**From:** Rich Elliott <elliotttr@kvfr.org>  
**Sent:** Monday, October 14, 2013 11:38 AM  
**To:** Jeff Watson; Dan Valoff  
**Cc:** Brenda\_J\_Nelson@rl.gov  
**Subject:** RE: LP-12-00001 Reecer Ranch Notice of Application

**Subject:** LP-12-00001 Reecer Ranch Notice of Application

REECER RANCH PLAT  
A PORTION OF THE EAST 1/2 OF SECTION 28,  
TOWNSHIP 18 NORTH, RANGE 18 EAST, W.M.,  
KITTITAS COUNTY, WASHINGTON

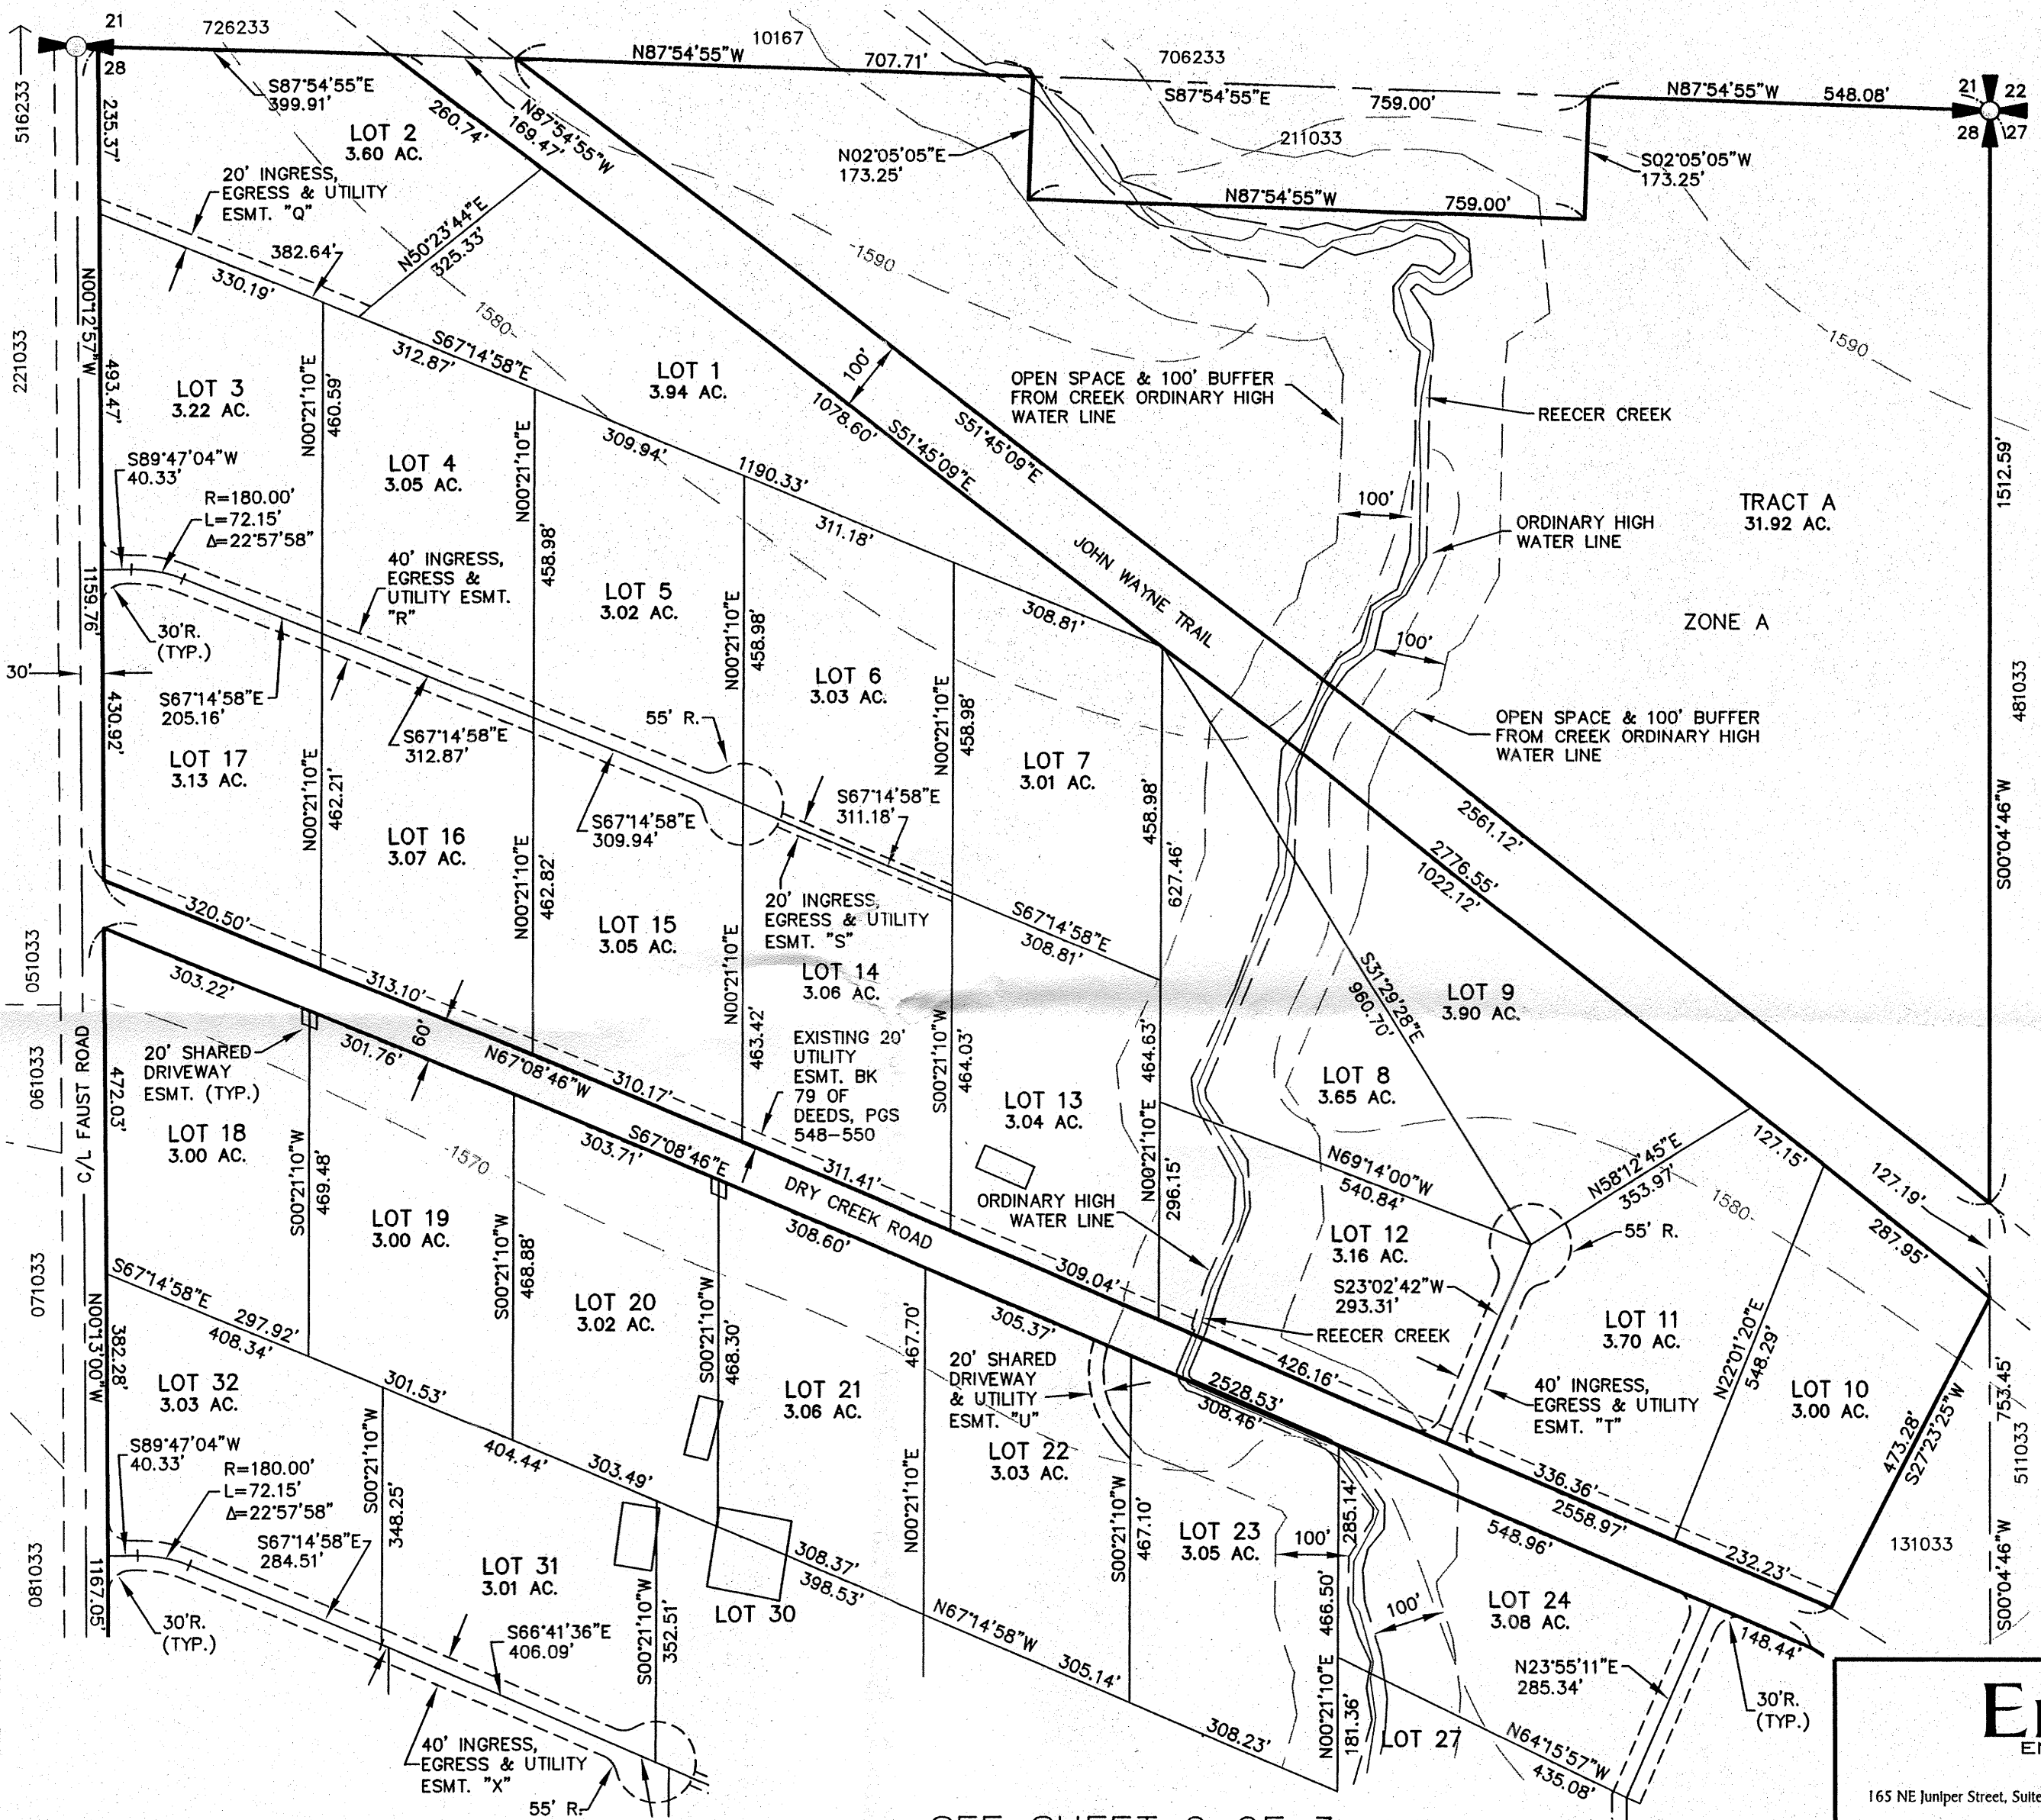
- KVFR does not support the concept of on-site static water storage if another alternative is available. The City of Ellensburg's water main is immediately adjacent to this project and we would strongly support a hydrant system to serve this project.
- Access to all parcels will need to comply with Appendix D of 2012 IFC.
- Addressing to all structures will need to be clearly visible from the public road from either direction of travel.
- It is possible that the WUI Code will be adopted by time or permit application and that would necessitate an assessment and possible code application.
